Planning Department
Brennon Williams, Director

May 4, 2022

Re: Little Stars Day Care
1500 Coors Blvd NW
Traffic Circulation Layout
Architect's Stamp 04-13-2022 (J11-D045)

TCLIO

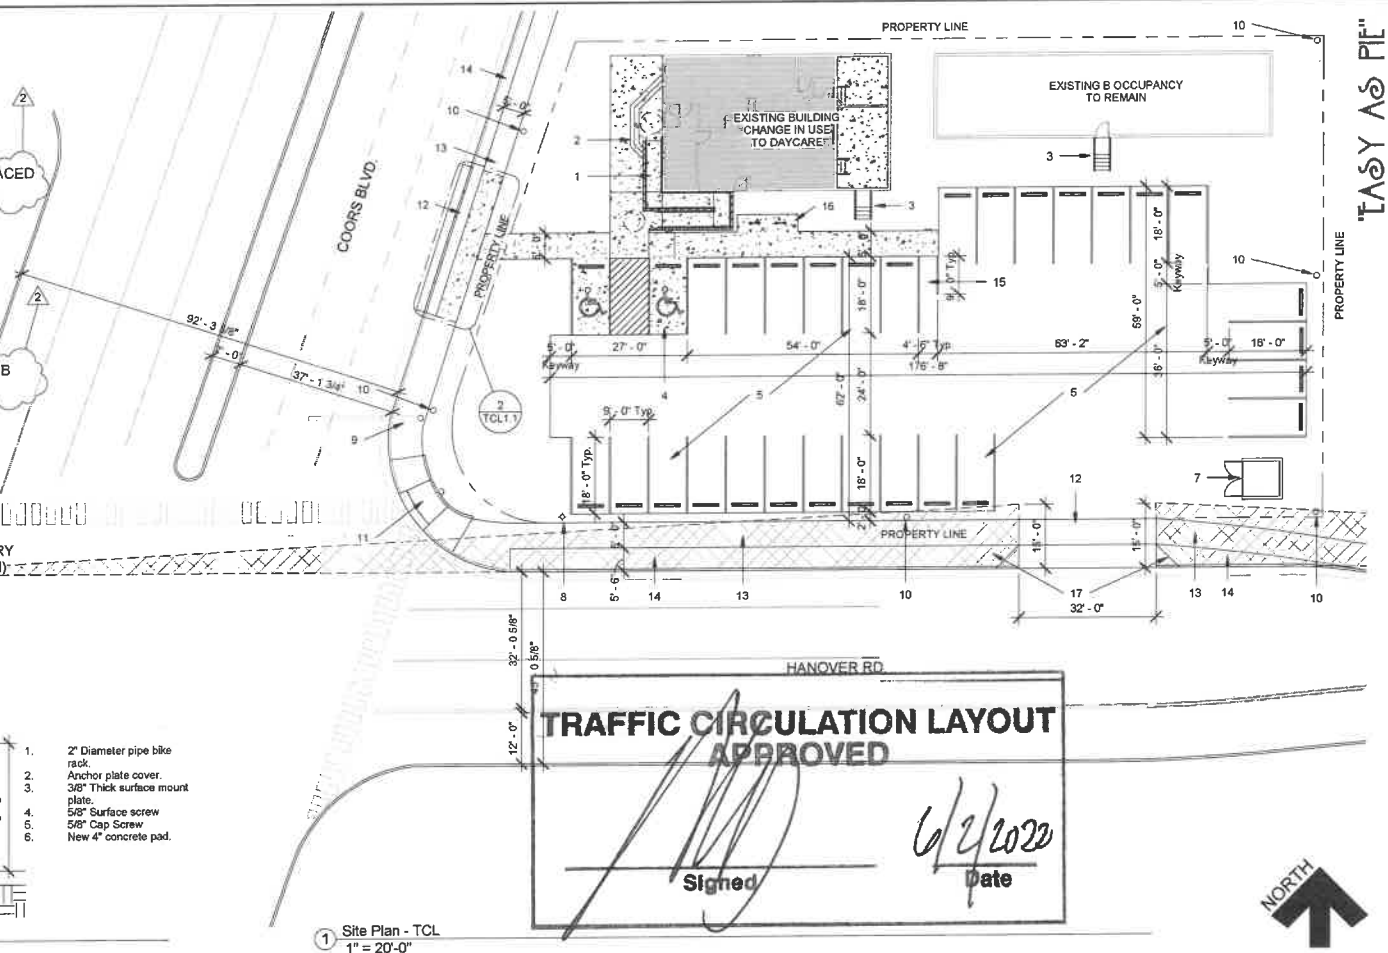
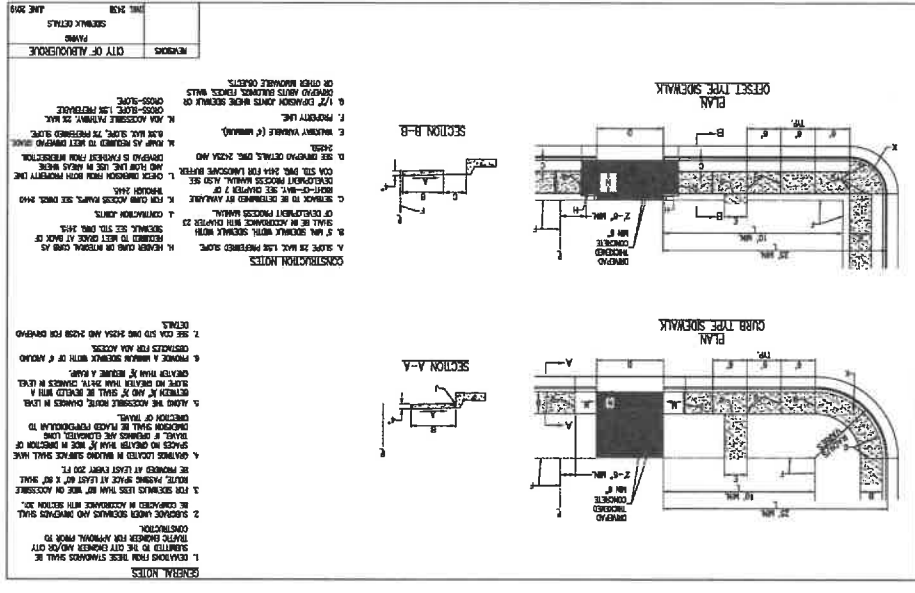
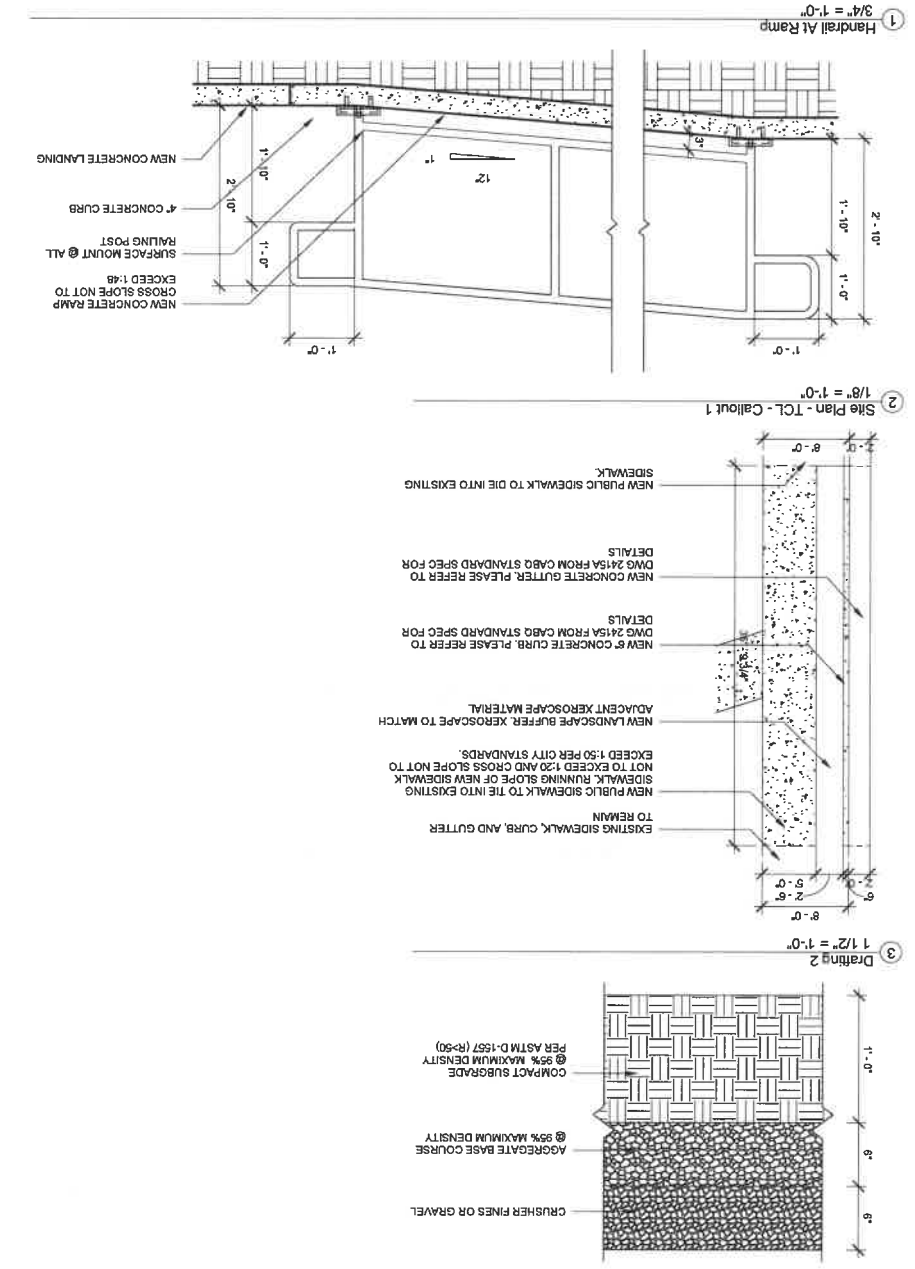
1. Detail 9 (Enlarged Ramp Plan):

- The pathway width will need to be 4 ft in width from inside to inside and not outside as shown.
- You need to provide another detail demonstrating the height of the railing (to include handrail detail without stair and shown curb or barrier edge protection per ADA Accessible Design).

2. Keyed Note 12: The existing drivepad will need to be closed. Unused curb cuts/drivepad must be replaced with sidewalk and curb & gutter. A build note must be provided referring to the appropriate City Standard drawing (2430 & 2415A).

3. **Keyed Notes References:** All references are calling out sheet WCL43 instead of TCL 1.0. Please adjust sheet number/title and the references notes.

5. **Drive Aisle and Parking Area:** A hard driving surface (asphalt and/or concrete) will be required as part of this proposed project for parking area and drive aisles. Provide concrete/asphalt design for ADA parking stalls and access aisle. According the Key Note 5 you are proposing to use existing Crusher Fines. This will not be acceptable because:

- Crusher fines are mostly used for pedestrian access stabilizer, trails. You will have to substantiate by following some type of standards that will justify drive surfaces as a usage for crusher fines.
- The crusher fines are existing and the compaction rate has been deteriorate over usage as well as the stabilizer. So, the 75,000 pounds support will not be justified on an existing condition without proper testing to determine the overall existing density as a stabilizer.
